From: [REDACTED]
To: [Norfolk Vanguard](#)
Subject: Norfolk Vanguard Project 010079.
Date: 23 March 2020 21:31:10
Attachments: [viewpoint3landform2.png](#)
[viewpoint7landform2.png](#)

I would like to comment on the applicants response to the request for information on the control of noise during operational phase. I am very concerned that the operational noise limit set at 35dB 5 minutes and 32dB 15 minutes is not being questioned. Up to now, every body involved, have been satisfied with the noise limit set for the Vanguard and Boreas substations, as it was simply set at the same level as the Dudgeon substation, already built on the same site. The Dudgeon noise limit can be verified on page 6 of the Planning Permission Document 3PL/2012/070S/F.

Plate 25.2 Norfolk Vanguard onshore project substation without mitigation (calculation in 1.5m above ground)

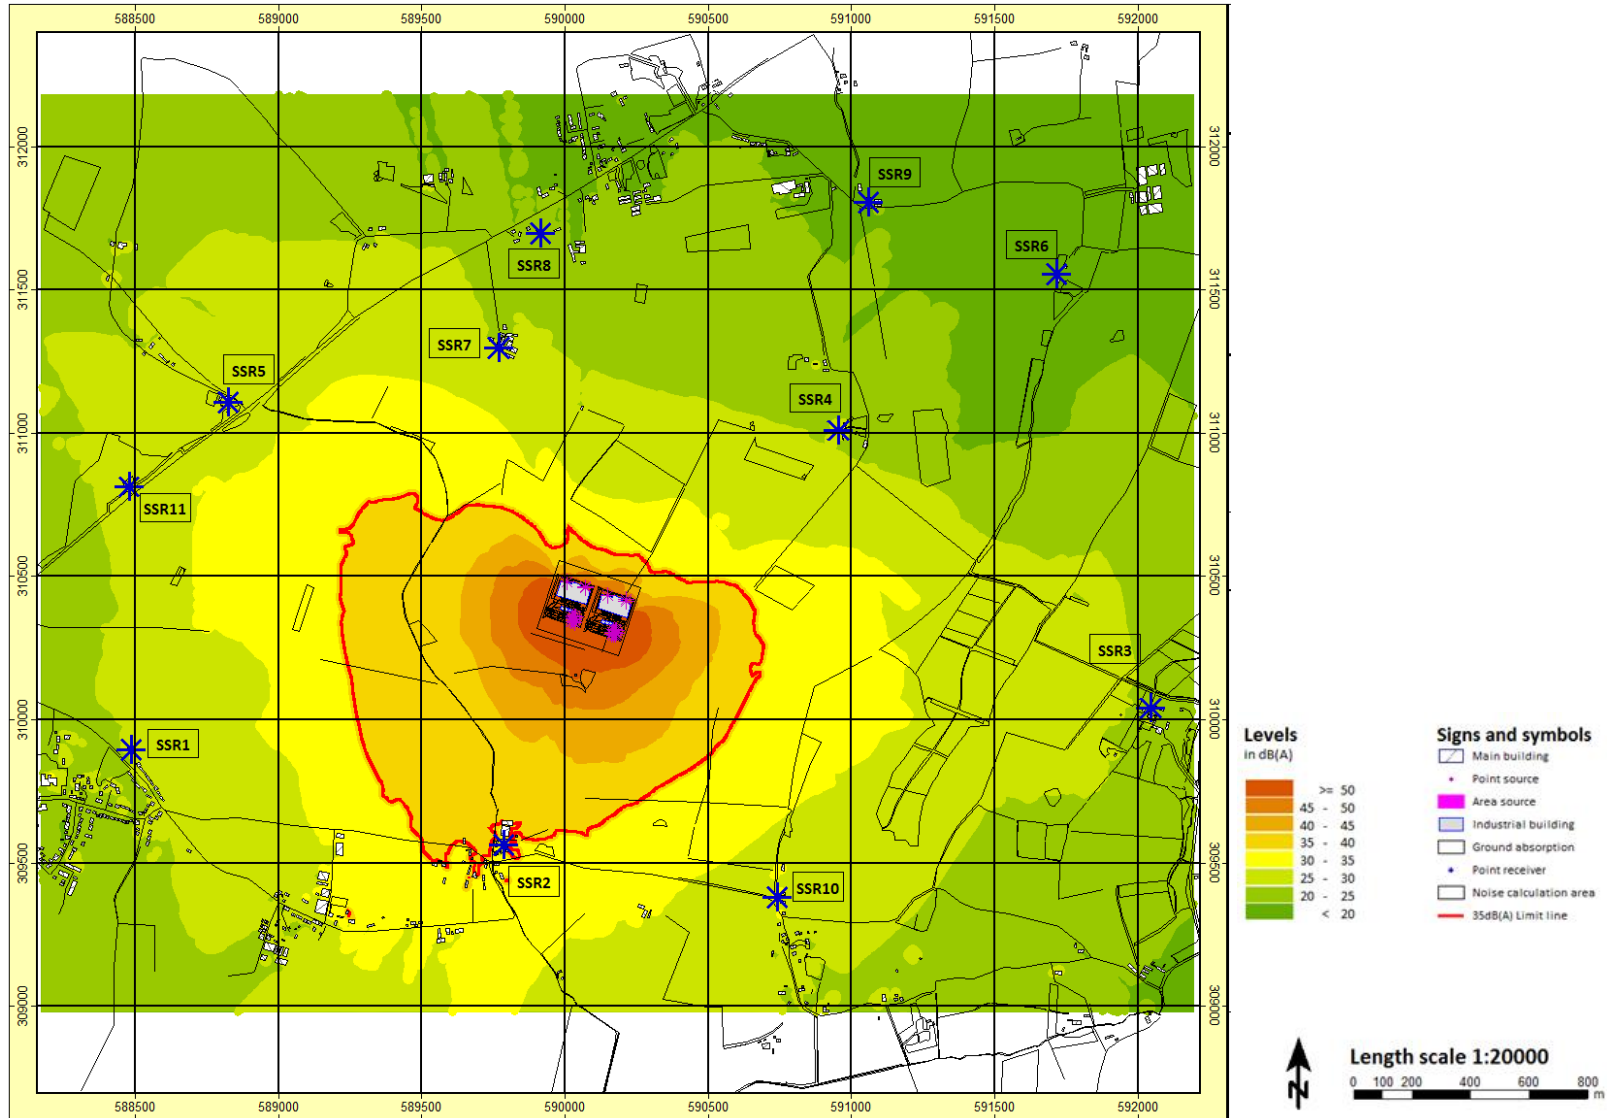
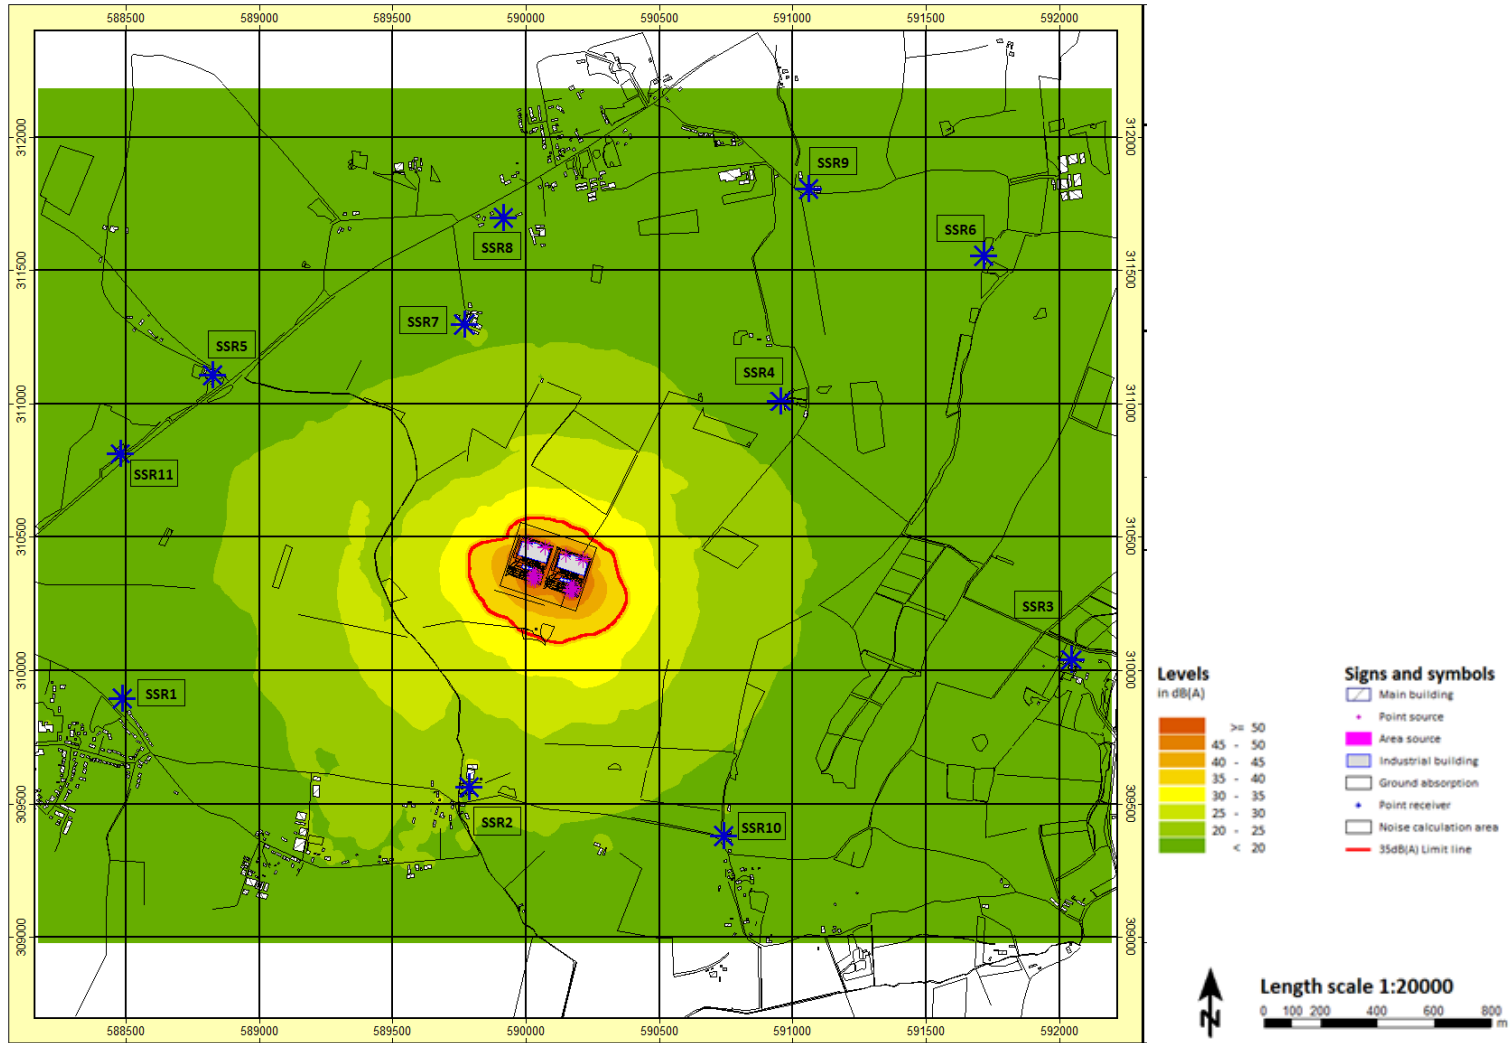
There is a massive difference being over looked. The noise limit is set at the edge of the nearest noise sensitive receptor, based on the measured baseline background noise. The nearest noise sensitive receptor to Dudgeon, is a house positioned very close to the very busy A47 main road. With the almost constant traffic noise, the arithmetic average measured background noise will be relatively high. In contrast, the nearest noise sensitive receptor to the Vanguard and Boreas substations is a house in Ivy Todd, a quiet hamlet of 11 houses.

The applicant states in their comments on deadline 5 submissions, regarding the Boreas application ExA.ASR.D6.V1 Deadline 6 Colin King's submission, that the arithmetic average sound level recorded at SSR2 (Ivy Todd Farm) was 28.4dB between 28/4/17 and 5/5/17. And yet Breckland Council set the same limit as Dudgeon, 35dB 5 minutes 32dB 15 minutes, seemingly ignoring the baseline background noise measured by the applicant. As this limit stands, the Vanguard substation will be heard in Ivy Todd, West End Bradenham, and by Vale House, virtually constantly.

I am more than concerned that with the best attention of the applicant, and Breckland Council, and their joint effort, through the WTG meetings working to BS.4142. that no account of the existing nature of the most affected area, of closest residents is being used. In an urban or industrial area, it is acceptable to set a noise limit slightly higher than to average background noise, as it would be difficult to decipher from the many existing noises. In naturally quiet areas, like Ivy Todd and West End Bradenham, where on still days only bird song, and an occasional distant dog barking can be heard, it is I believe normal to set the noise limit 10dB below the average background level, as there are so few existing noises to loose the constant operational noise amongst.
